**City of Portland, Maine - Building or Use Permit Application**

Permit No: 02-1035	Issue Date:	CBL: 339 C015001
-----------------------	-------------	---------------------

Proposed Project Description:  
Construct 22' x 20 Attached Garage with 10' x 5' Breezeway

Application Number: 2-1035

PROJECT NUMBER:
A-0238
DATE: **9-2-02**
DRAWING NUMBER:
A-2
SHEET NO. **4 of 5**

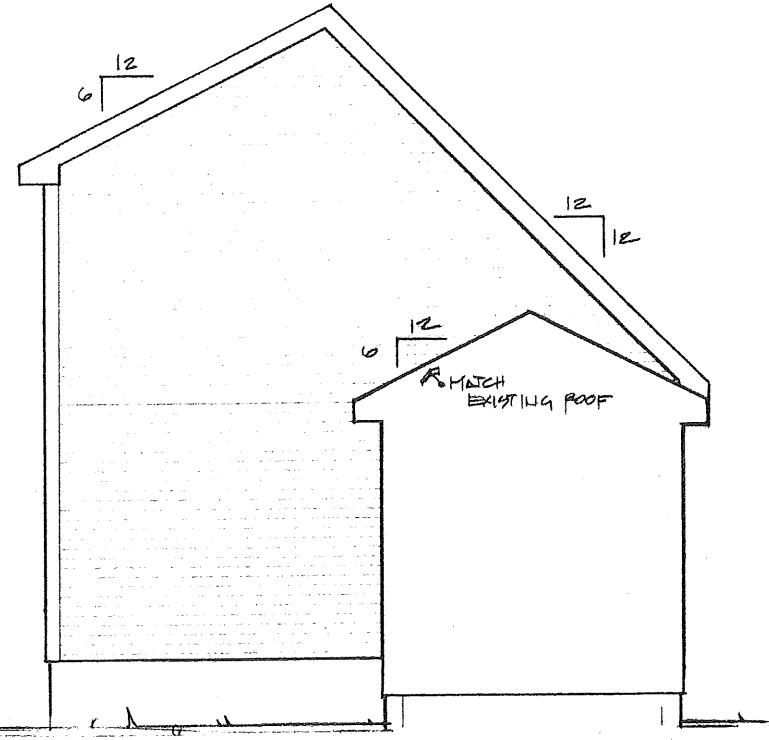
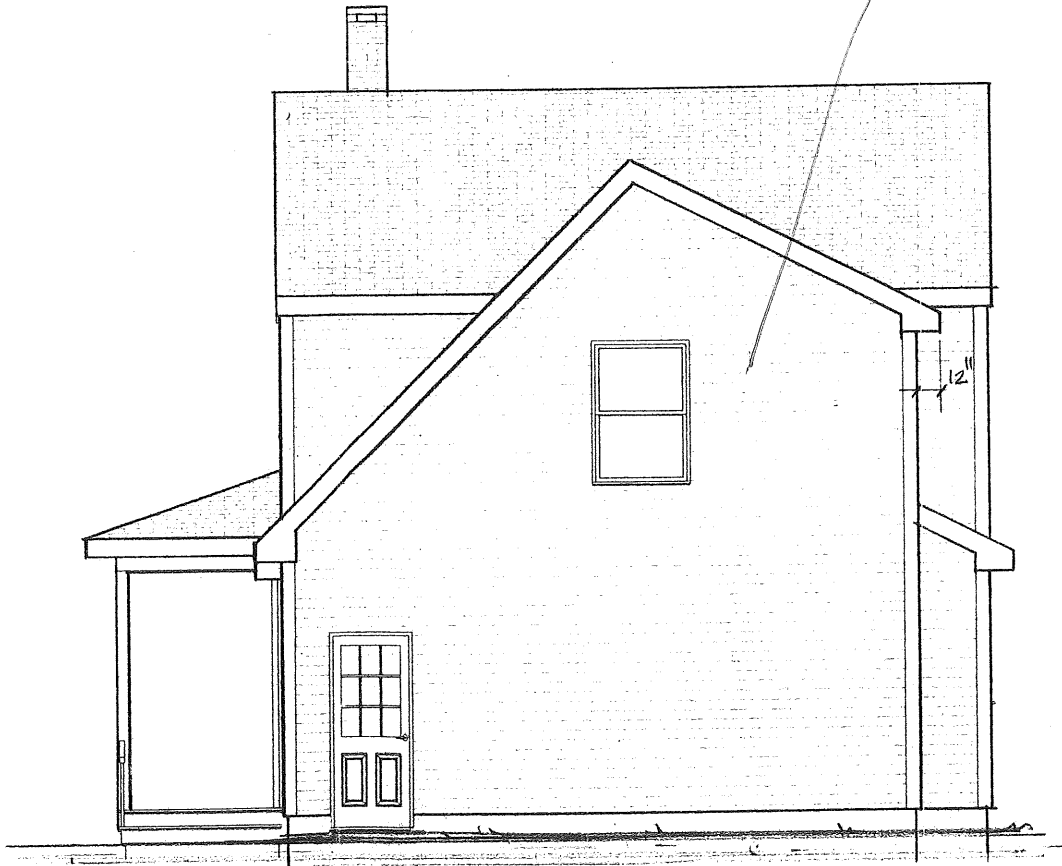
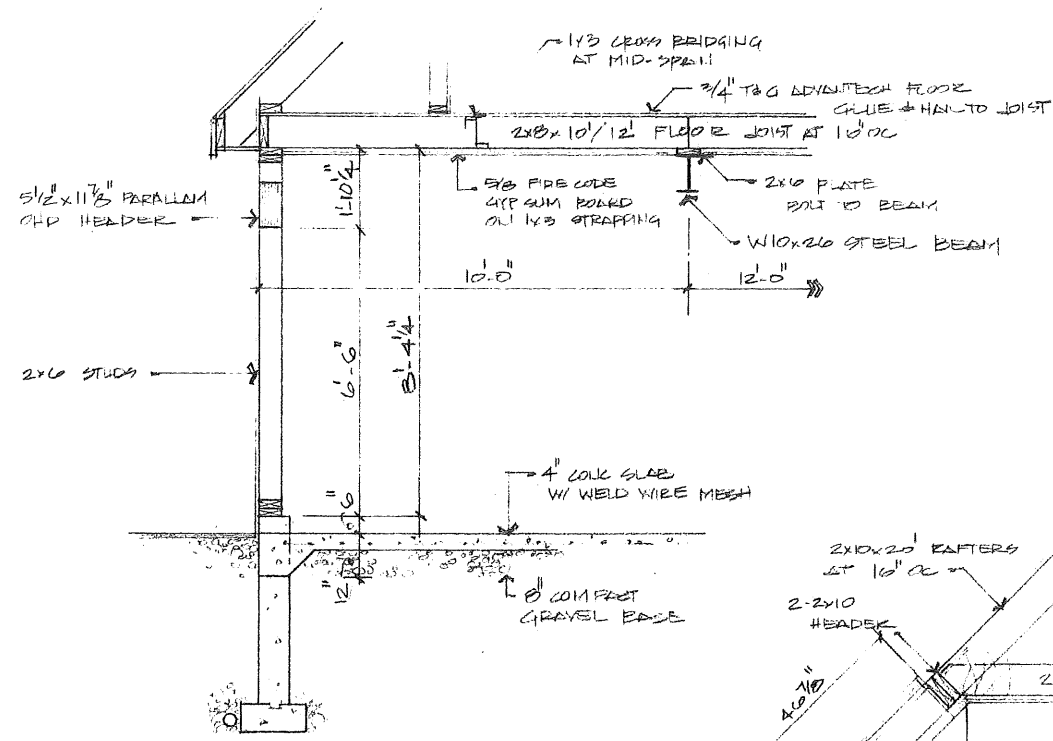
Comments: 9/20/02 scaled setbacks on a site plan are different from the numbers put on and changed on plan. I am questioning those setbacks. Also need a floor plan for above garage - what is the use. Also no structurals included. Left v-mail 0/26/02 owner says there are pins and the given

SECTIONS
 DRAWINGS PREPARED BY:
JERRY DUGAL & CO. INC.
 1036 Pinkham Brook Rd
 Portland, ME, 04222
 Tel. 207-353-5915
 Fax 207-353-1638

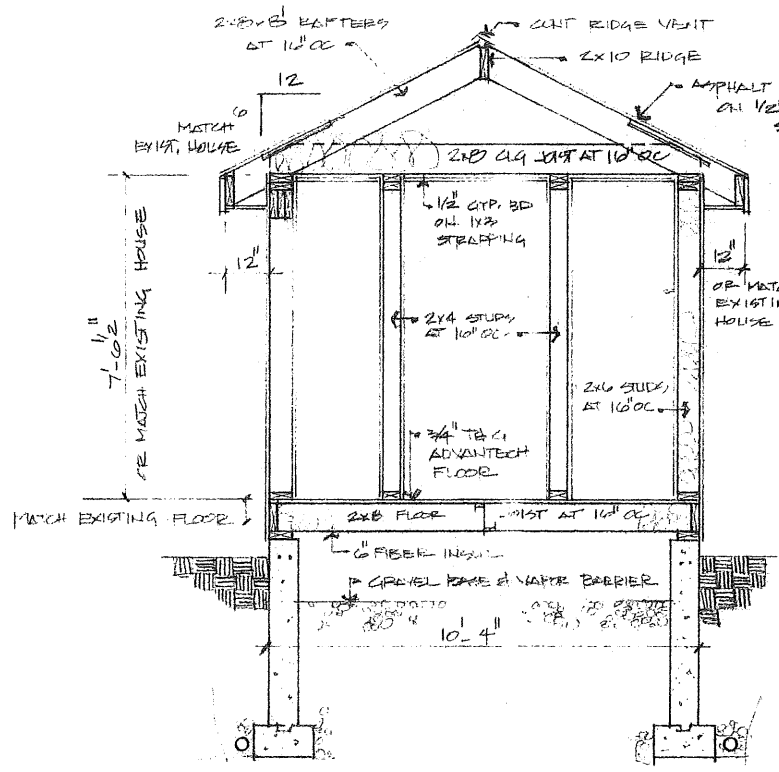
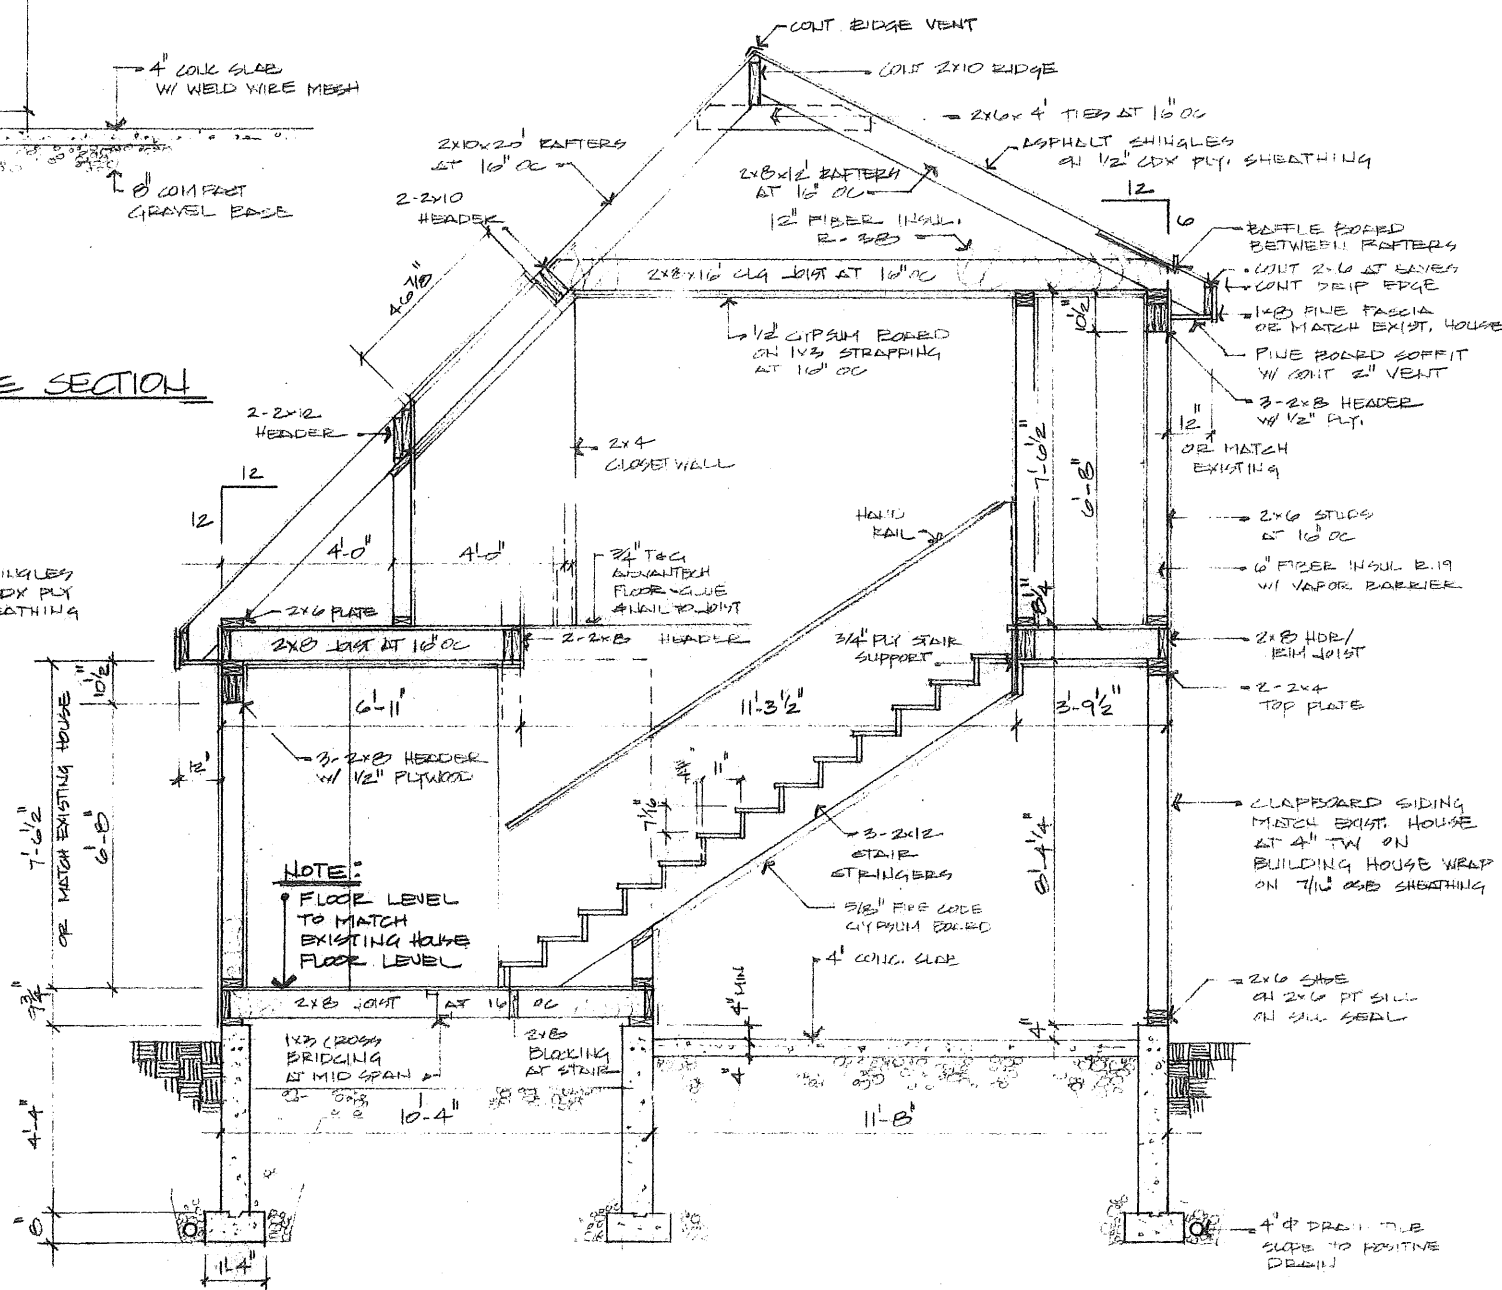
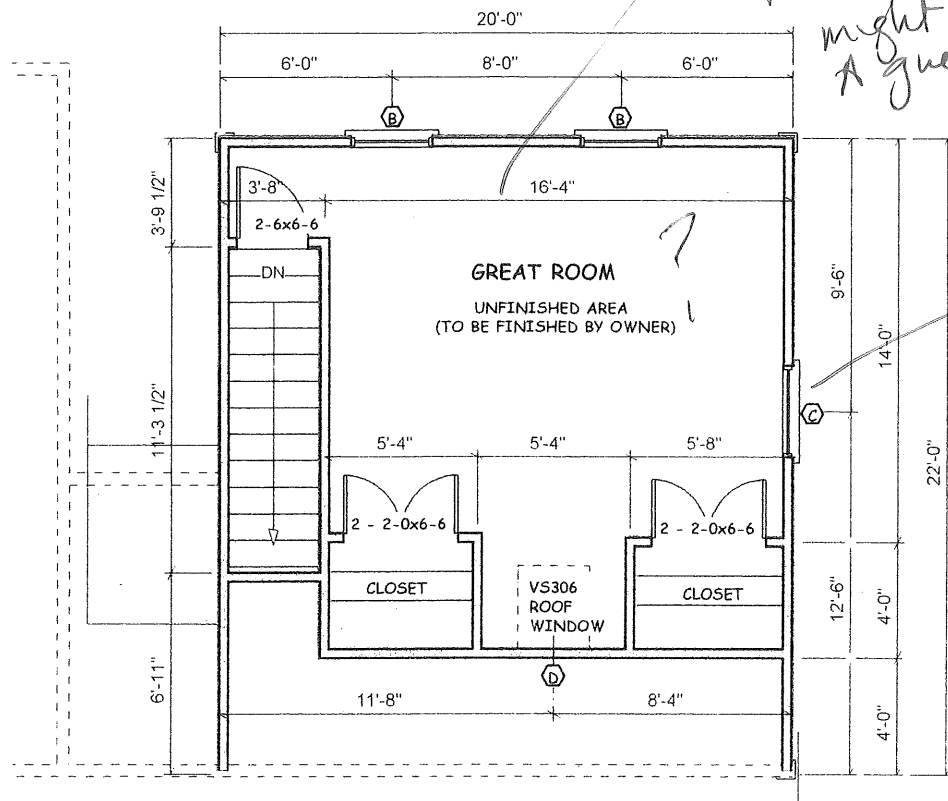
Comments: 10/07/02 left v-mail for Scott Proctor  
 10/9/02 Scott called back and verified will submit specs on  
 lam beams & steel. He asked what height the ceiling joists  
 could be placed at to get a cathedral.  
 10/22/02 left v-mail for Scott Proctor

Contractor shall submit specs on all engineered lam beams and steel
